HISTORIC PRESERVATION BOARD

September 6, 2016

Re: 135 Park Street
CBL: 039 A014

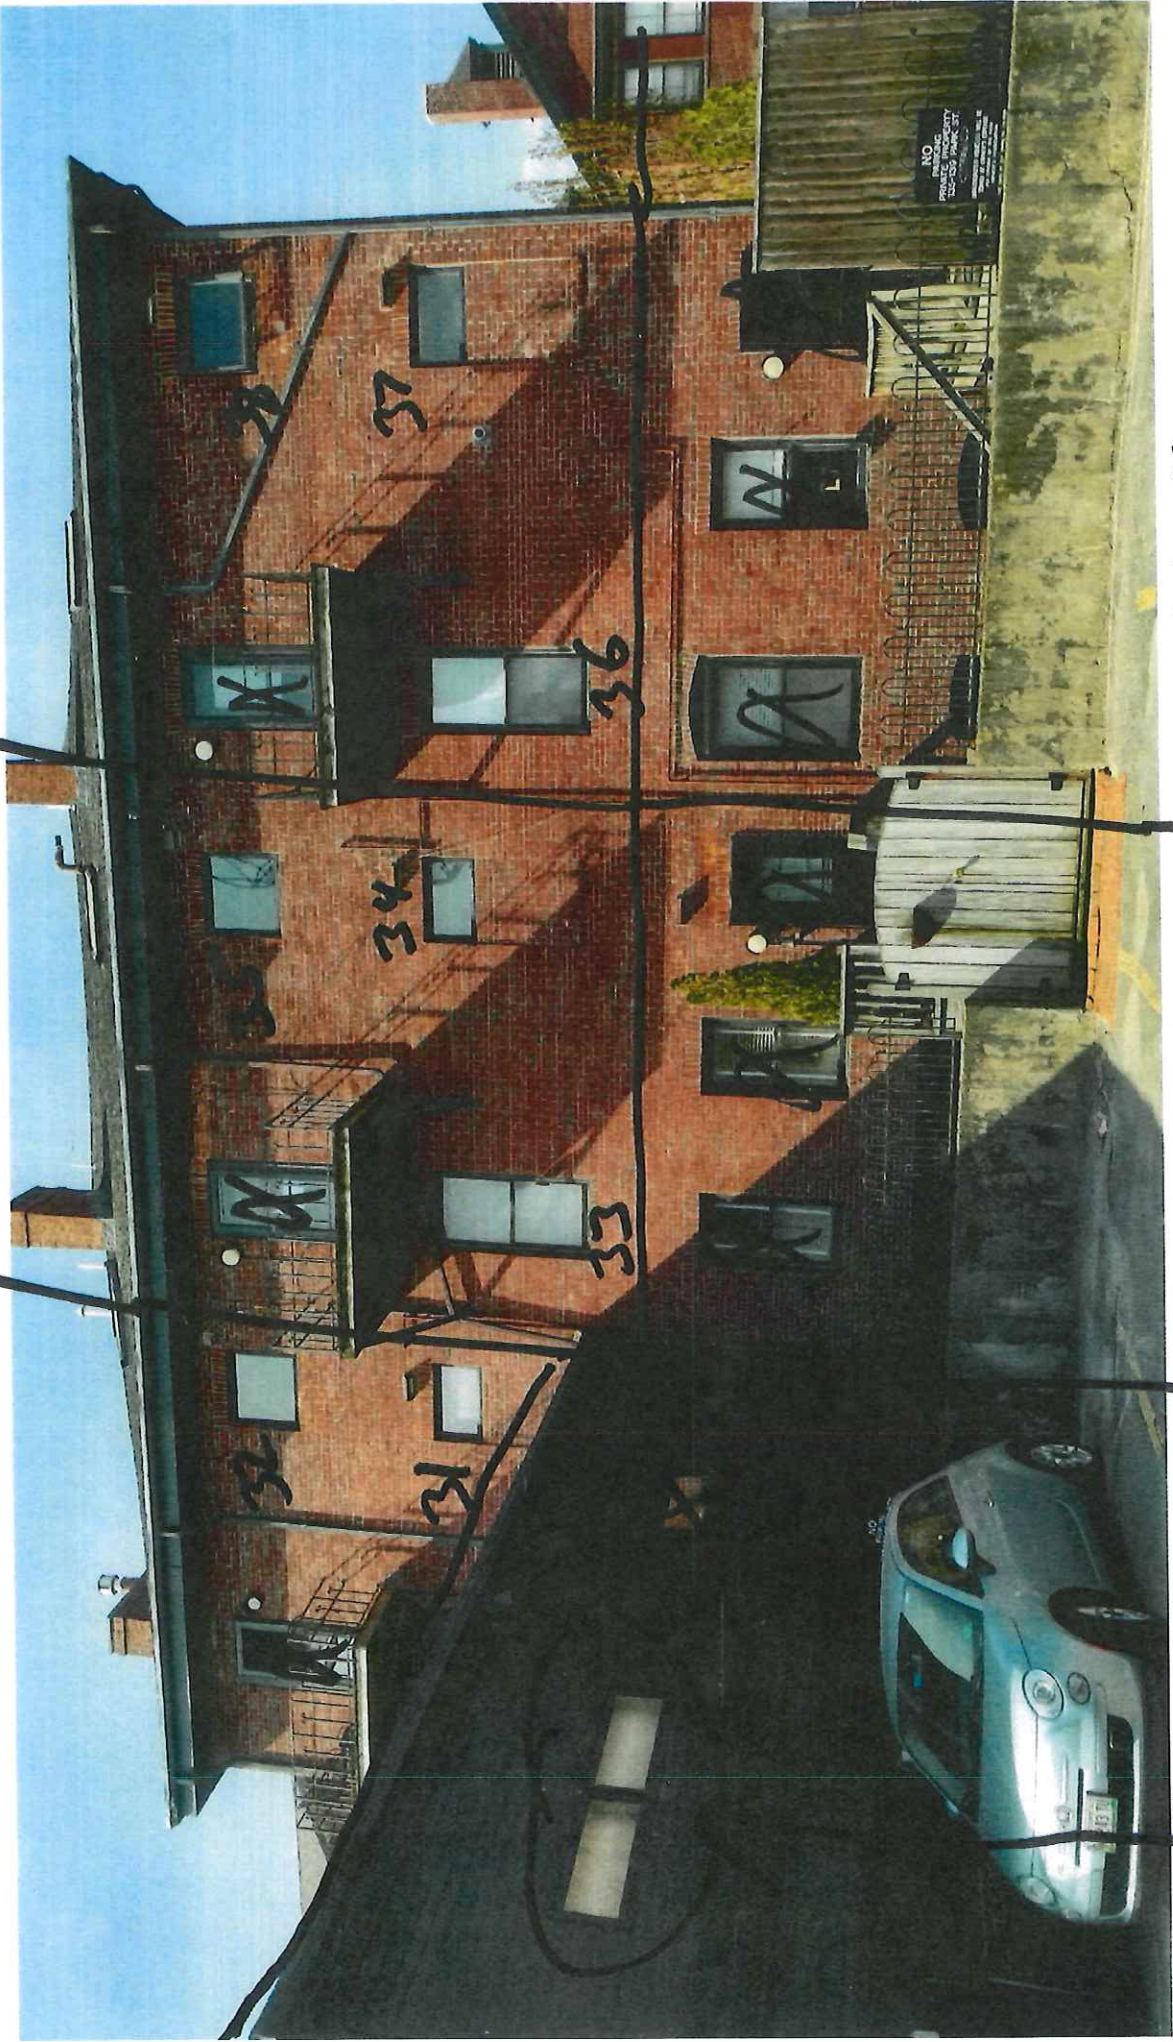
This office has approved your application to replace twenty-six windows on the front (24) and southeast end (2) of your property at 135 – 139 Park Street. Approval is based on the plans and specifications included in the application dated June 3, 2016 (revised window specifications supplied later by Rufus Deering Company and by Kent Gordon,) and is subject to the following conditions:

1. HP staff understands the windows are to be Jeld-Wen full-unit (not inserts) clad windows in black, with 5/8" putty glaze profile muntins - simulated divided lights (SDL) on the interior and exterior, with spacer bars. It is understood that the first and second floor windows will be 6/6 and the third floor windows are to be 3/3.
2. If screens are desired they are to be half screens.
3. Visual transmittance of the glass (VTR) is to be .7 or greater, so glass appears clear, untinted, and non-reflective.
4. Painted wood casing and brick mould is to be reproduced on site after window installation, with approximately 2" of flat casing with a staff bead moulding (Brosco B691) on top, at the edge of the masonry opening.
